Rampion Two Offshore Wind Farm

Appendix N6 to Natural England Deadline 6 Submission

Planning Inspectorate Reference EN010117

01 August 2024

Contains OS data © Crown Copyright and database right 2020. © British Crown and OceanWise, 2021. All rights reserved. License No. EMS-EK001-727447. Not to be used for Navigation. Derived from https://www.ices.dk/ March 2021

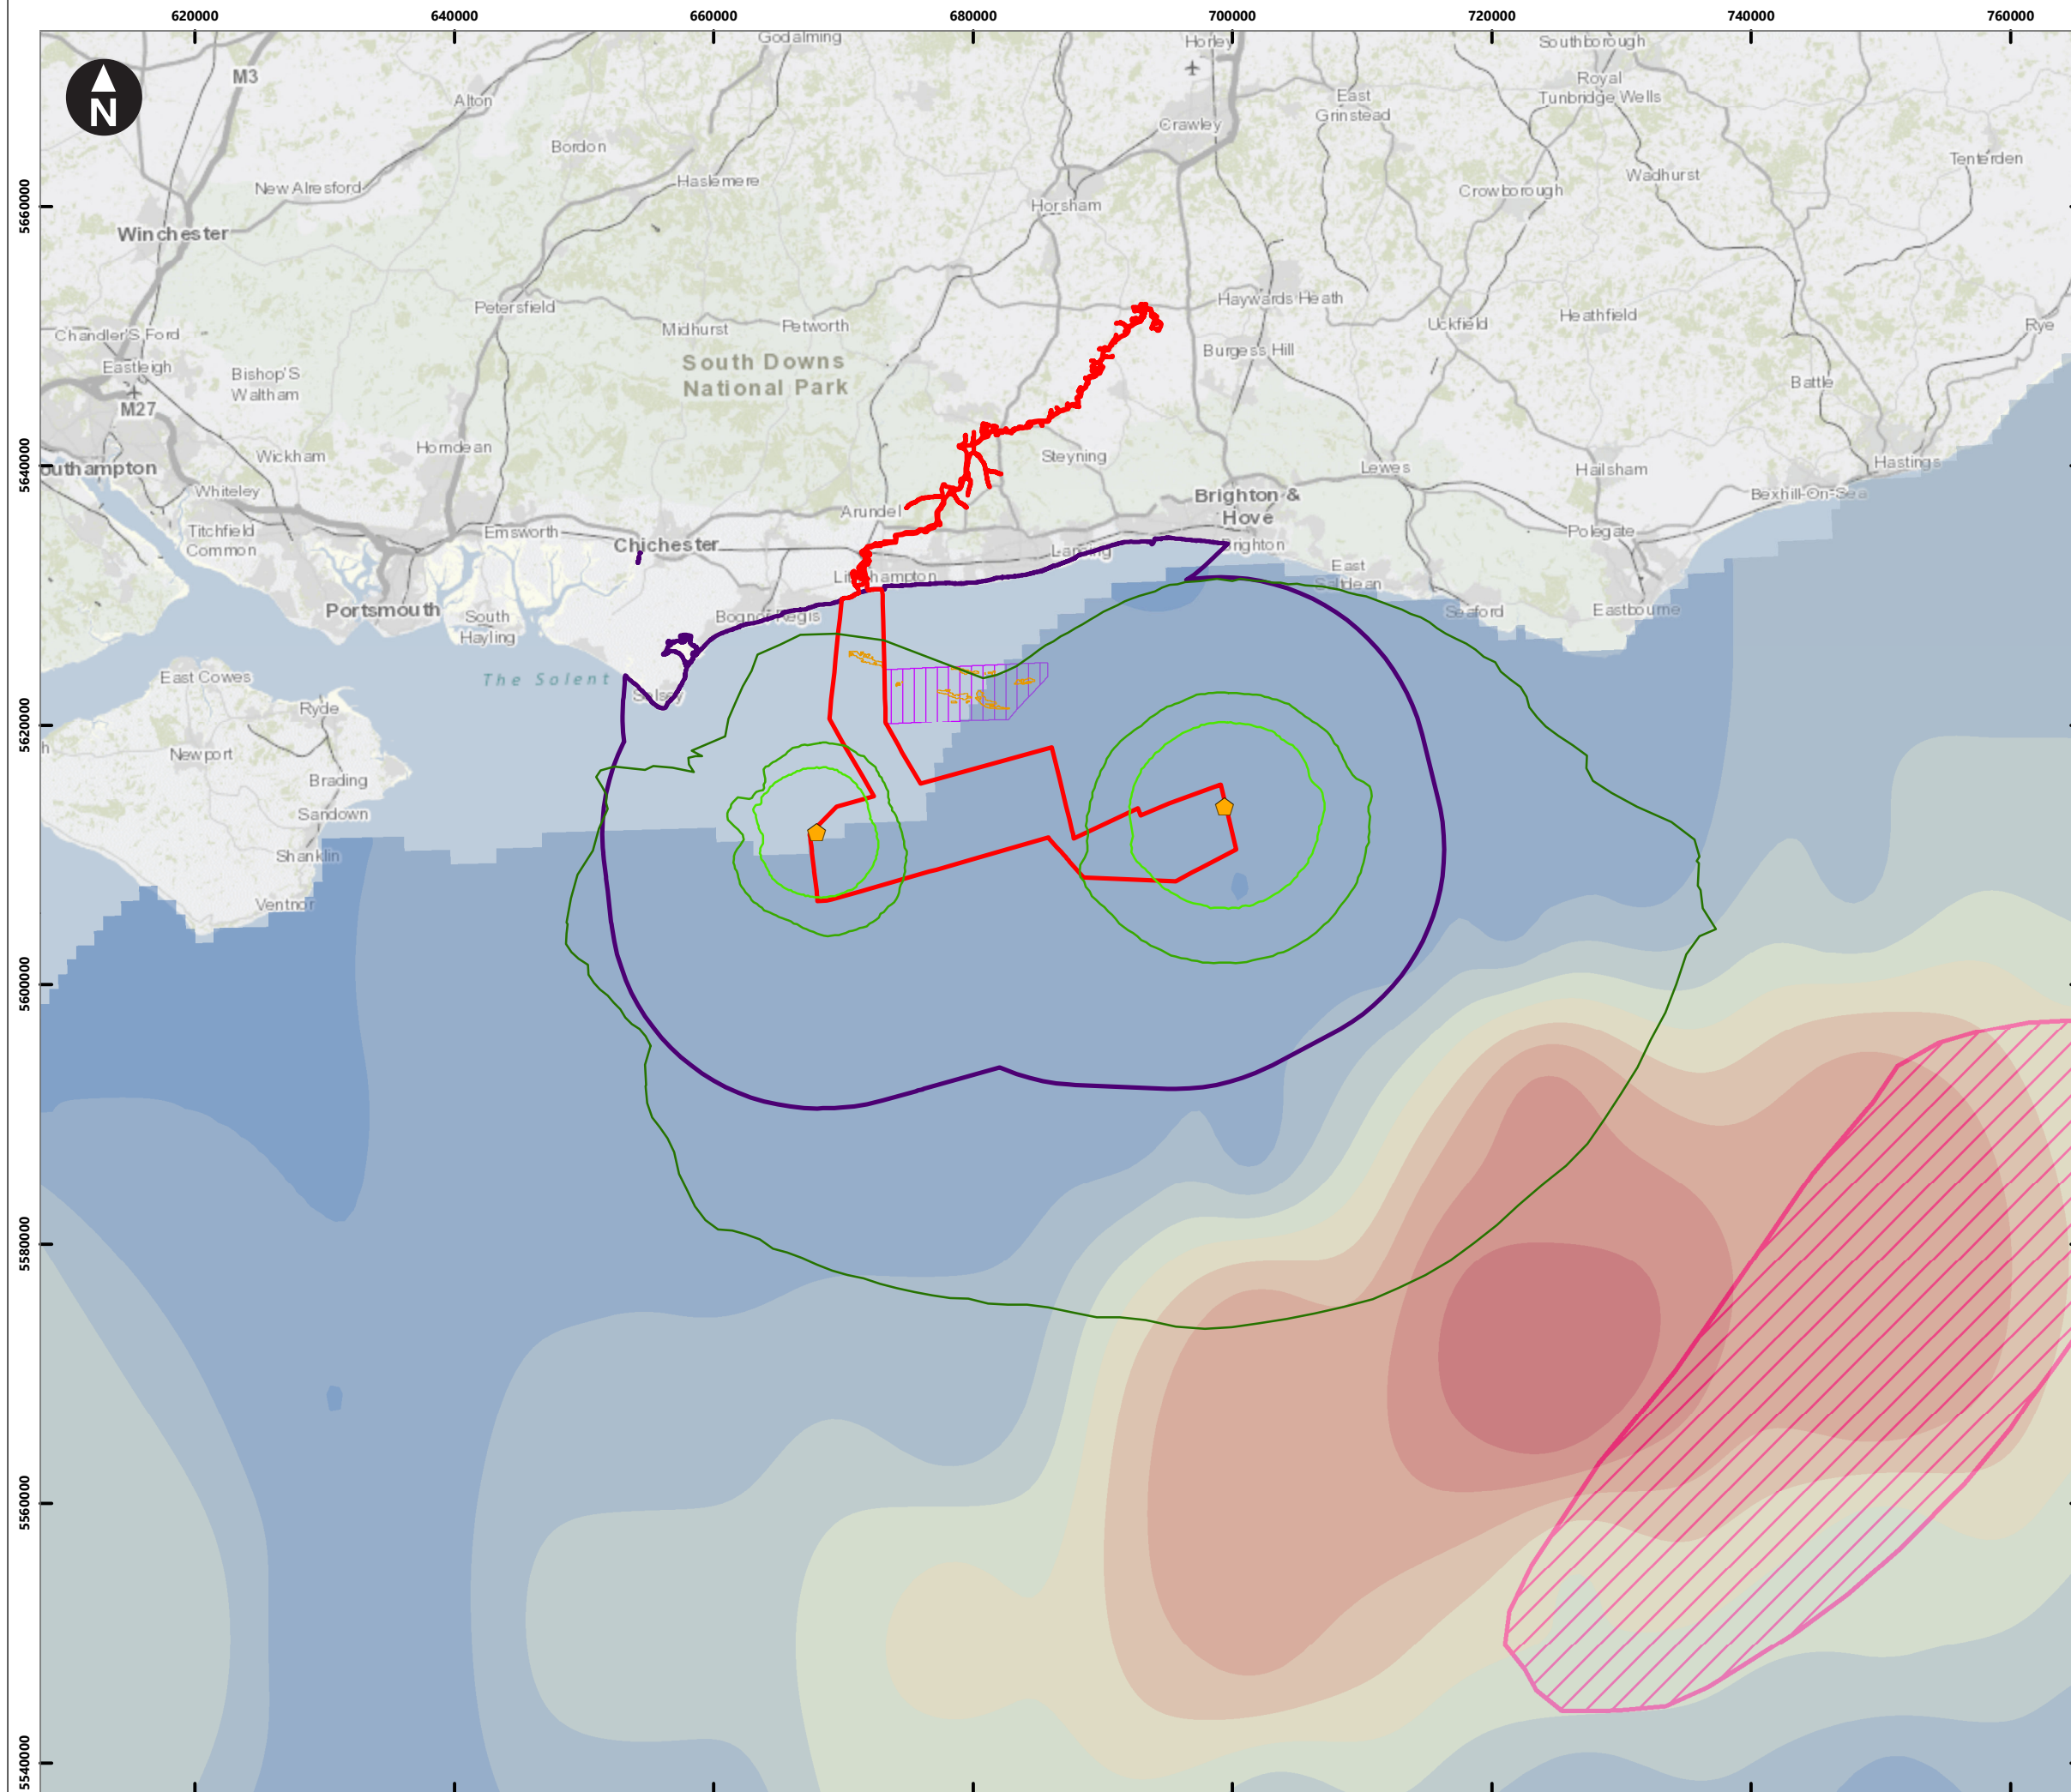
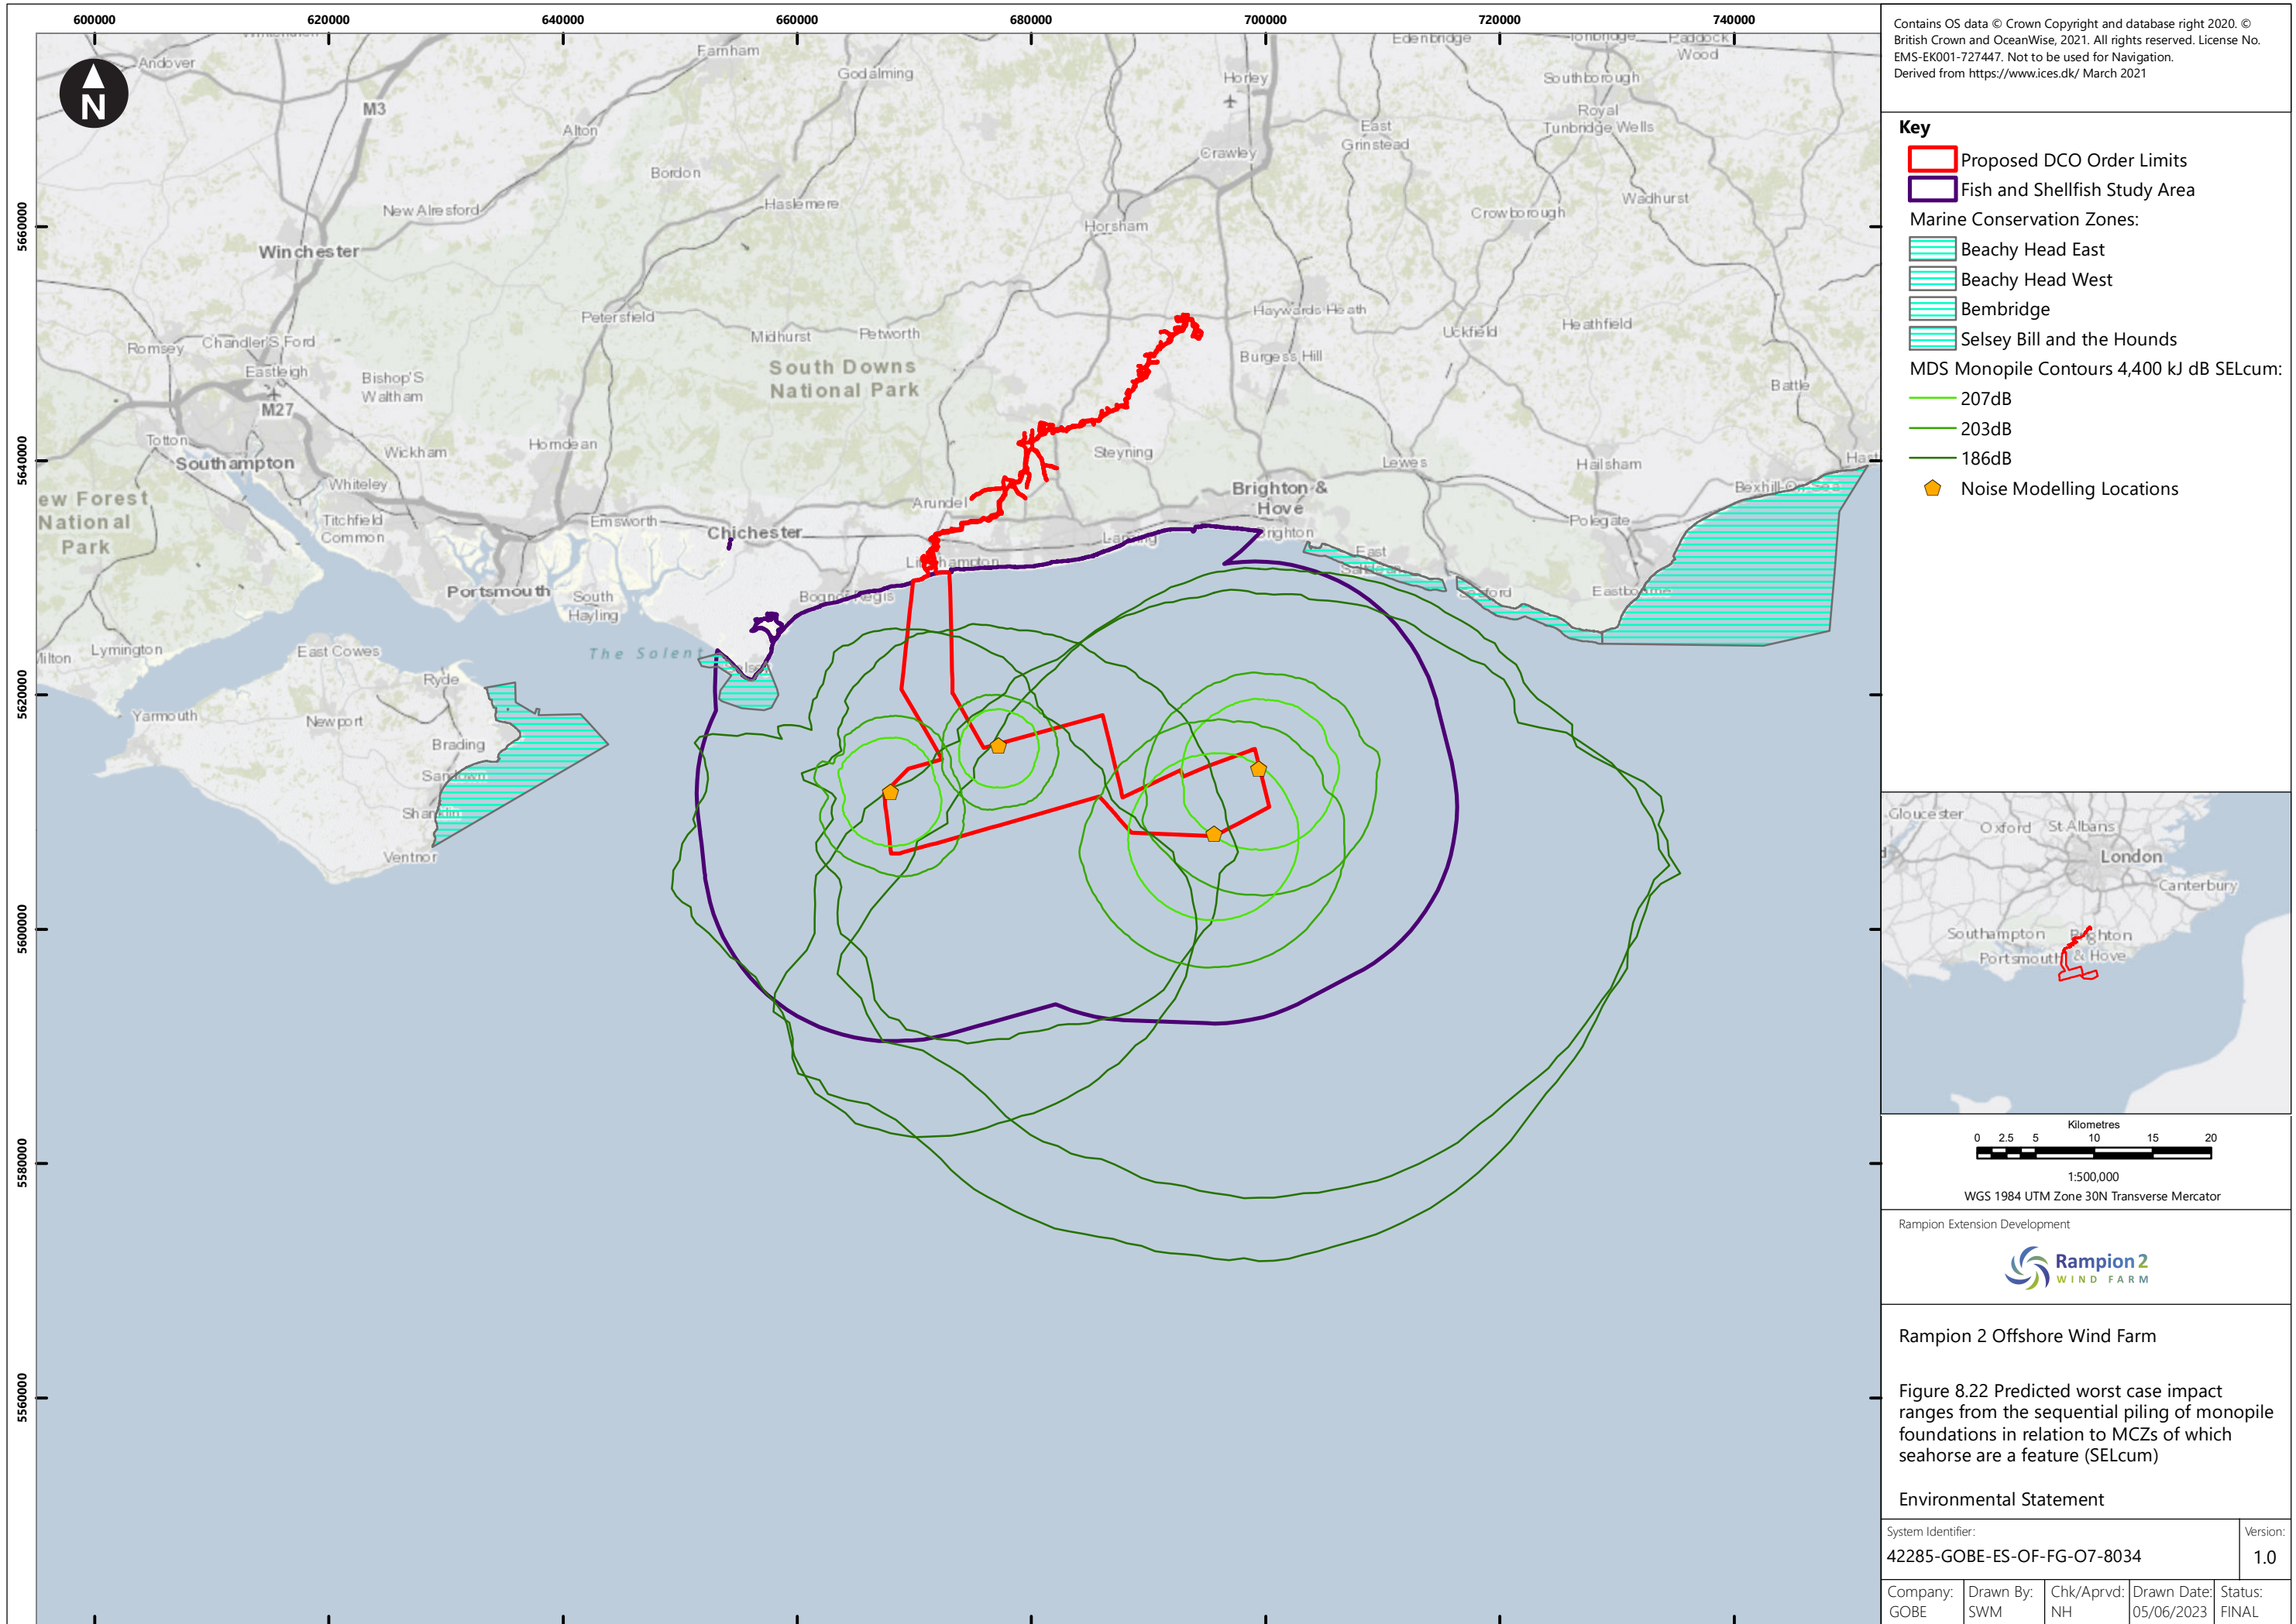
FS 3.1	<p><i>Worst Case Scenario – Piling Noise for Fish and Shellfish</i></p> <p>The Applicant Natural England</p>	<p>The ExA notes that Natural England has remaining concerns/questions with regards to the modelling of underwater noise and the worst-case scenarios for different situations [REP5-139,Page 2]. It states:</p>	<p>Natural England provided detailed comments on our position regarding fish and shellfish at Deadline 5. Where appropriate we have updated this position based on further information provided at Deadline 5 and provided directly by the Applicant on the 26/07/2024. Natural England have provided</p>

<p><i>“We advise that a clear explanation of whether sequential or simultaneous piling has been modelled as the worst case in each situation still needs to be provided and each figure needs to be clearly labelled with which scenario it is demonstrating. Additionally, as raised in our Relevant Representations (Appendix E, Point 27), where piling is conducted simultaneously at two locations we question what the closest distance between locations is likely to be, and how this is considered in terms of impacts on the MCZ’s.”</i></p> <p>The ExA also acknowledge that the Applicant has responded on these matters raised by NE, such as the response to Point E27 at Deadline 1 [REP1-017], for example</p> <p>The ExA requests the Applicant and Natural England resolve these issues before the close of the Examination. If the parties are unable to resolve these matters, provide a joint Position Statement and the options available to the Secretary of State.</p>	<p>updated advice in Appendix E6 of this submission on this point.</p> <p>Natural England has not seen a position statement from the Applicant.</p>
